memorandum

date December 6, 2018
to Evan Maxim, Interim Development Service Director
from Scott Olmsted, ESA
subject Review of 5637 Mercer Way – Response to Public Comment

Environmental Science Associates (ESA) has prepared this memorandum on behalf of the City of Mercer Island (City). The purpose of this memo is to respond to public comment on the proposed project located at 5637 Mercer Way and the potential need for further site investigation and wetland impact assessment.

<p>THE HEALEY ALLIANCE AZ 2505 N 25th DRIVE, GOODYEAR, AZ 85526 • (480) 444-6766 ARCHITECTS</p>	<p>Mi Treshouse, LLC, 5631 EAST MERCER WAY MERCER ISLAND, WA.</p>	<p>SITE PLAN DATE: 03/20/24 DRAWN BY: [Name] CHECKED BY: [Name] SCALE: 1" = 20'</p>
--	---	--	--

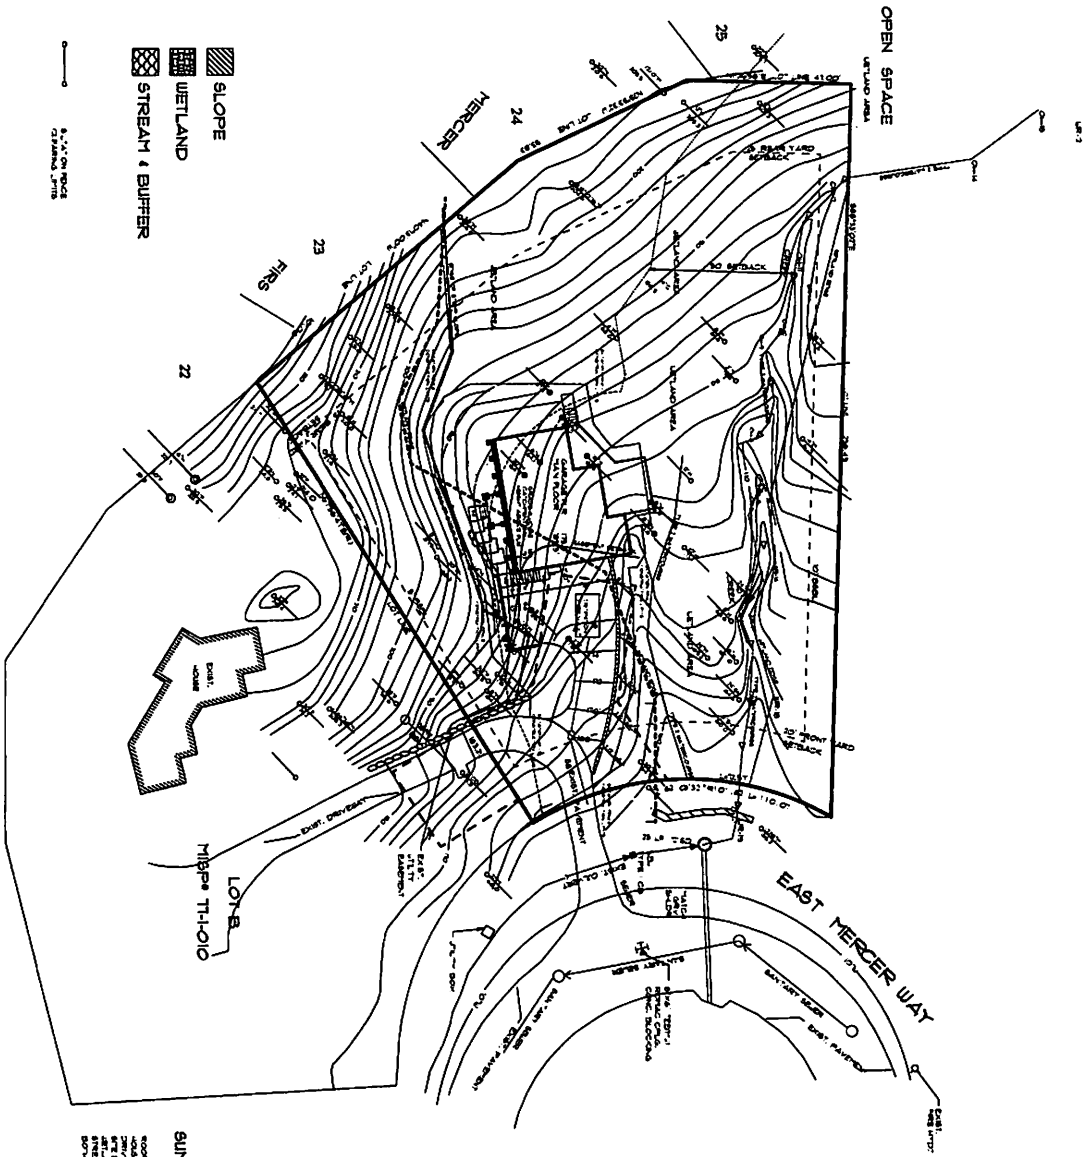
Mr. Anderson noted that the proposed grade of the garage floor, as shown on Sheet 1, 2018 Site Plan Wetland & Buffer Disturbance (The Healy Alliance AZ, 2018) is located below existing grade at the southwest corner of the house. The garage floor is located at 179.5 feet, the grade at the southwest house corner is 185 feet, and the grade at the backside of what appears to be a retaining wall is 193 feet. Although not shown on the plans, it is likely that a drainage system will need to be installed on the backside of retaining wall and adjacent to the building foundation to alleviate static pressure on these structures by transporting groundwater down-gradient. The retaining wall drainage system would likely impact wetland hydrology up-gradient of the wall by acting as a groundwater “sink.” Similarly, the foundation drainage system would impact wetland hydrology adjacent to the of the building (i.e., southwest). The extent and degree of impact to wetland hydrology is unknown at this time and ESA is not qualified to make this determination. ESA recommends that design plans detail the proposed drainage system for the project and the City consult a hydrogeomorphologist to determine likely impacts to wetland area.

Mr. Anderson also discussed a stormwater detention tank that was depicted on previous plan sheets immediately east of the building, underneath the proposed driveway. The applicant did provide preliminary stormwater calculations for this tank; however, Sheet 1, 2018 Site Plan Wetland & Buffer Disturbance (The Healy Alliance AZ, 2018) does not show a stormwater tank. Mr. Anderson points out that the tank’s proximity to the wetland boundary and required excavation to install may have a negative impact on wetland hydrology. The area around the tank may need to be backfilled with coarse material and drainage may need to be provided to address buoyancy of the tank. Should continuous drainage of the area surrounding the tank be required, this project element may act as a “sink” similar to the drainage system discussed above. ESA recommends the applicant provide additional details on the stormwater detention tank to address the potential for indirect impacts to the adjacent wetland.
